SUBMISSION REGARDING WESTCONNEX M4-M5 LINK MOD-3

I would like to submit the following concerns in relation to the **Iron Cove Ventilation Undergrounding Modification proposal - application number SSI 7485**:

Figure 1 Alignment of proposed new ventilation tunnel and caverns at Iron Cove

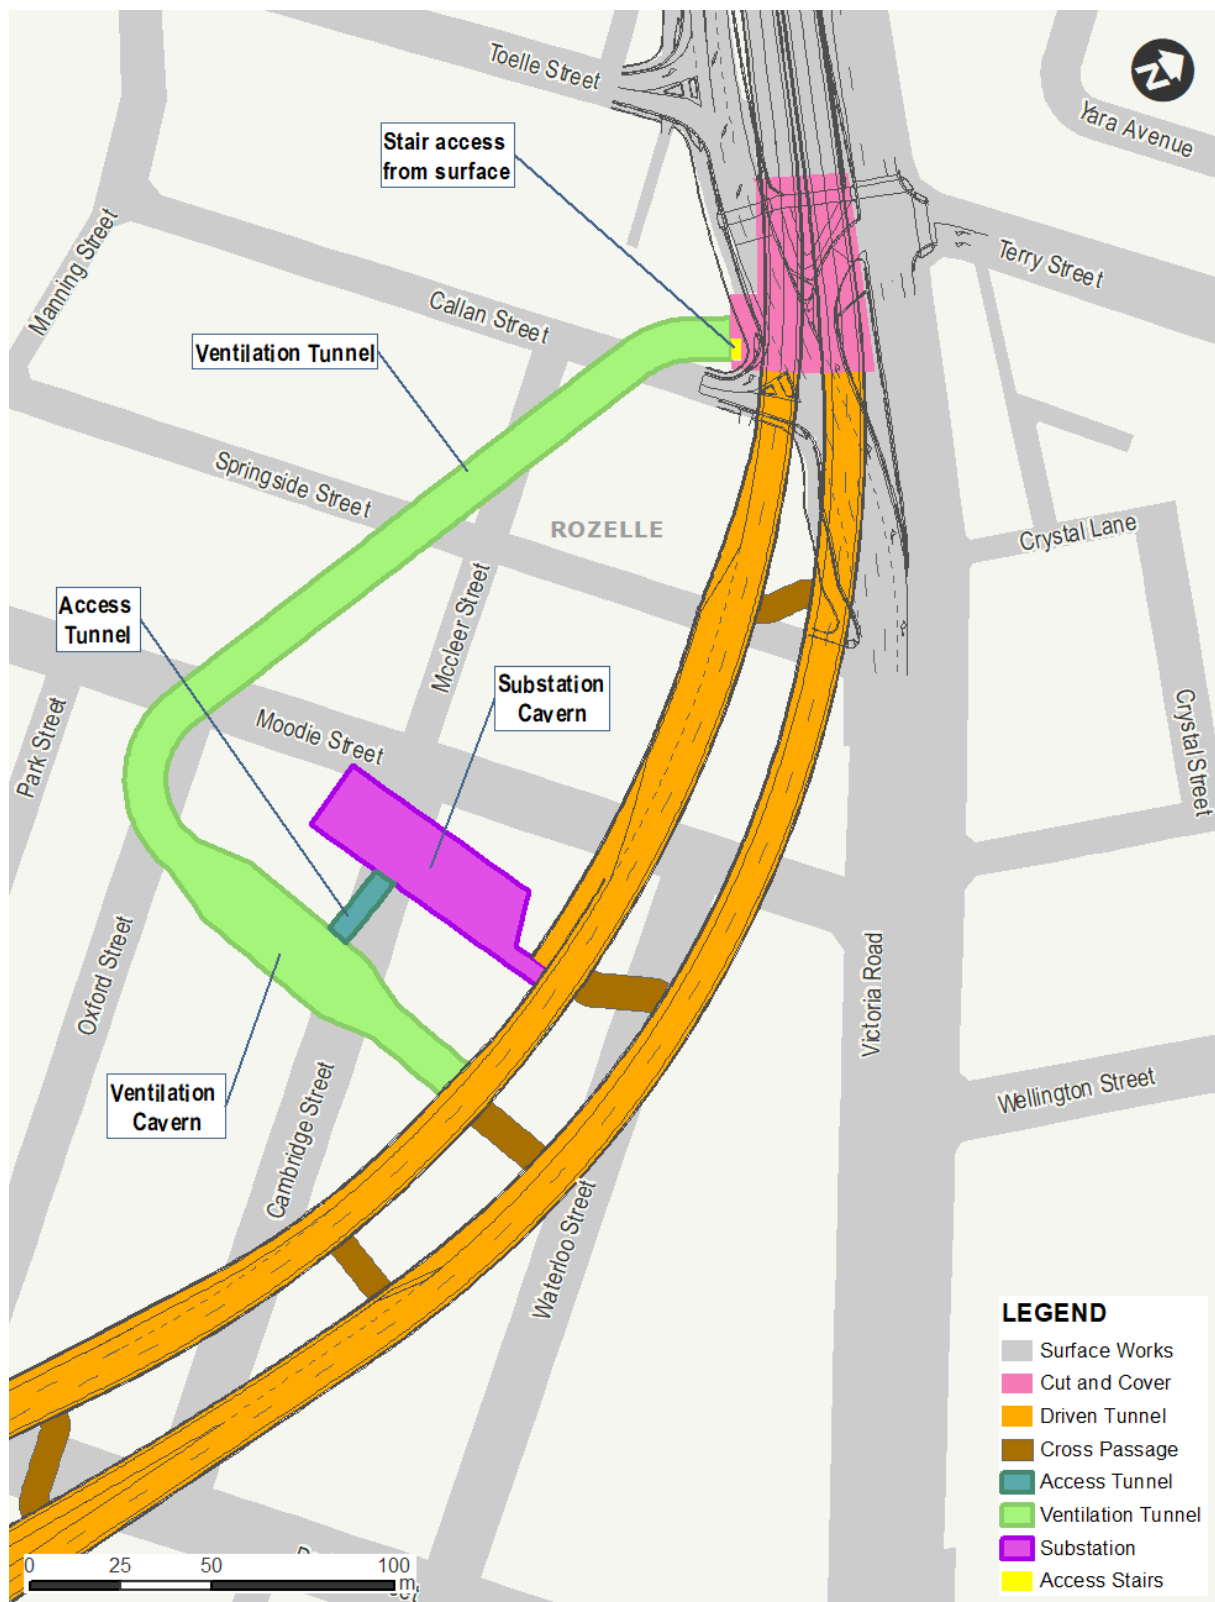
2. Depth, size and location of the ventilation tunnels and caverns

- The proposed modification to build ventilation tunnels and caverns and move some ventilation facilities underground will, in its current form, subject a significant additional number of residents to shallow tunnelling with associated disruption, risks of property damage and loss in property value.
- The size of the underground caverns appears to be significantly larger than the approved above ground buildings, and raises questions about the size of the underground footprint of the caverns. A larger than absolutely necessary footprint increases both the level of risk (of damage, ongoing noise & vibration) and the numbers of residents potentially impacted.

- Increasing the depths of the tunnels and caverns would help mitigate these risks, as would reducing the size of the caverns e.g. configure the equipment within the caverns in line with what was approved for the above ground facilities.
- It is disappointing that the alternative design option to locate the ventilation facilities underground within a ventilation building at a depth of 40 metres was dismissed. It is also disappointing that other alternative designs, impacting fewer residents, were not considered by this modification proposal. It would appear that relatively short-term construction impacts and project deadlines/profitability have been prioritised over the long-term impacts on those additional residents who will be directly affected by this proposed modification.
